City of Portland, Maine - Building or Use Permit Application

Permit No: 10-1443	Issue Date:	CBL: 012 F008001
------------------------------	--------------------	----------------------------

Past Use: Two Family	Proposed Use: Two Family / Replace side deck and stairs.	Permit Fee: \$30.00	Cost of Work: \$1,000.00	CEO District: 1
Proposed Project Description: Replace side deck and stairs.		FIRE DEPT: <input type="checkbox"/> Approved <input type="checkbox"/> Denied	INSPECTION: Use Group: Type:	
		Signature:	Signature:	
PEDESTRIAN ACTIVITIES DISTRICT (P.A.D.)				
Action: <input type="checkbox"/> Approved <input type="checkbox"/> Approved w/Conditions <input type="checkbox"/> Denied				
		Signature:	Date:

BUILDING A DECK???

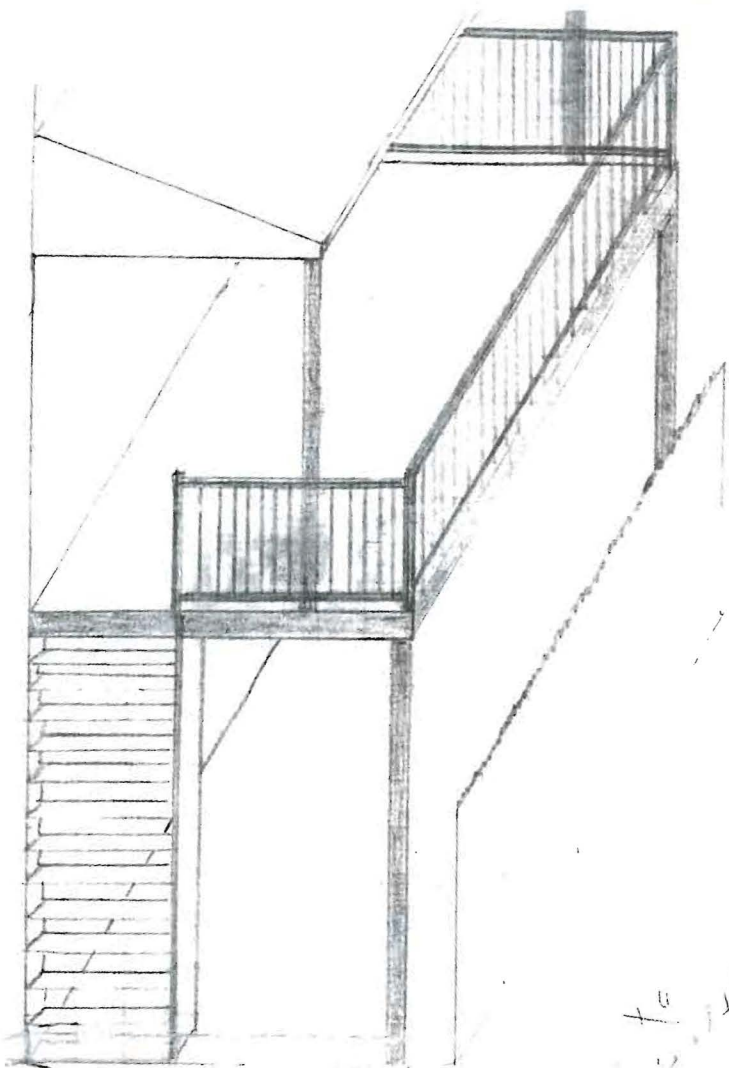
- 1) Fastener schedule per the IRC 2003
- 2) The existing deck shall be inspected for adequate fasteners and bearing for spans, and modifications may be required
- 3) Permit approved based on the plans submitted and reviewed w/owner/contractor, with additional information as agreed on and as noted on plans.
- 4) Frost protection must be installed per the enclosed detail as discussed w/owner/contractor.

12/29/2010-jrioux: Hold: roof load bearing and span issues.
